Charlotte Department of Transportation

Memorandum

Subject: Rezoning Petition 08-124: Located on the south side of East Boulevard between South Boulevard and Cleveland Avenue (*revised 10/24/08*)

01 SITE PLAN

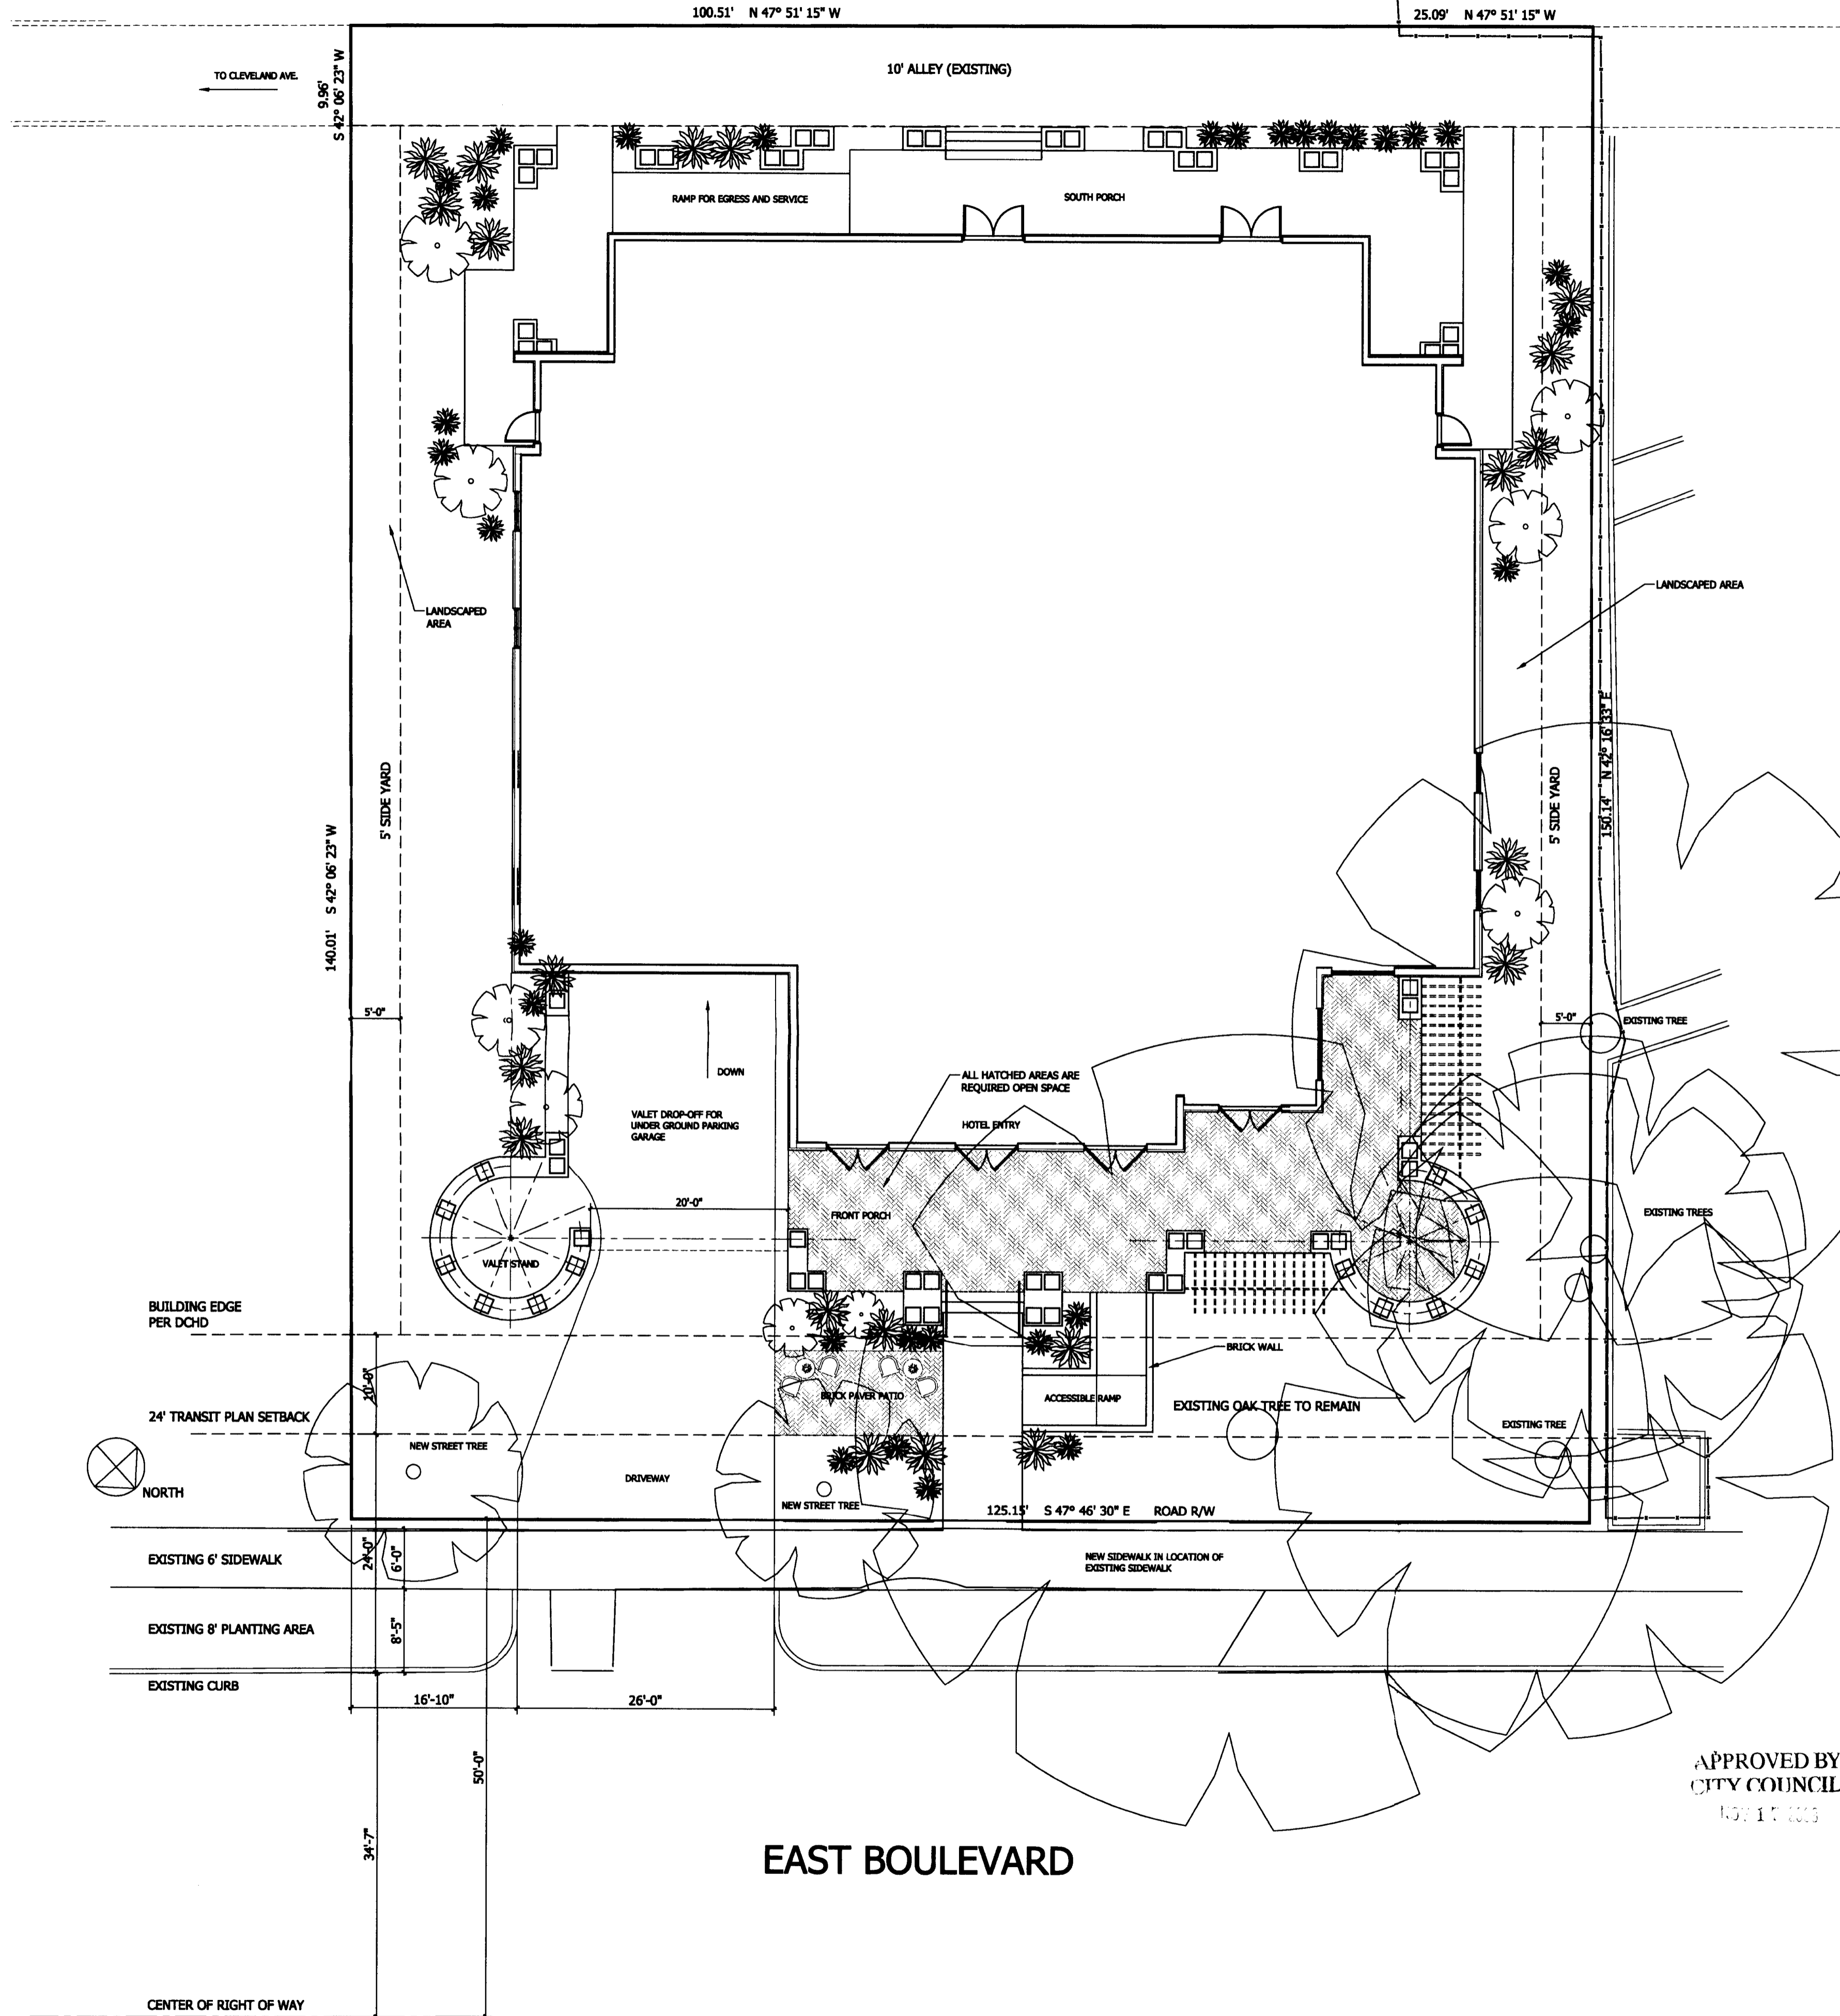
1. We are not in support of the request to eliminate the required on-site delivery/loading space. If this function is not provided on-site, then service vehicles will need to be stopped/parked in the alleyway in order to make deliveries and block access to other parcels accessed via the alleyway. (*Previous review comment – 2nd*)
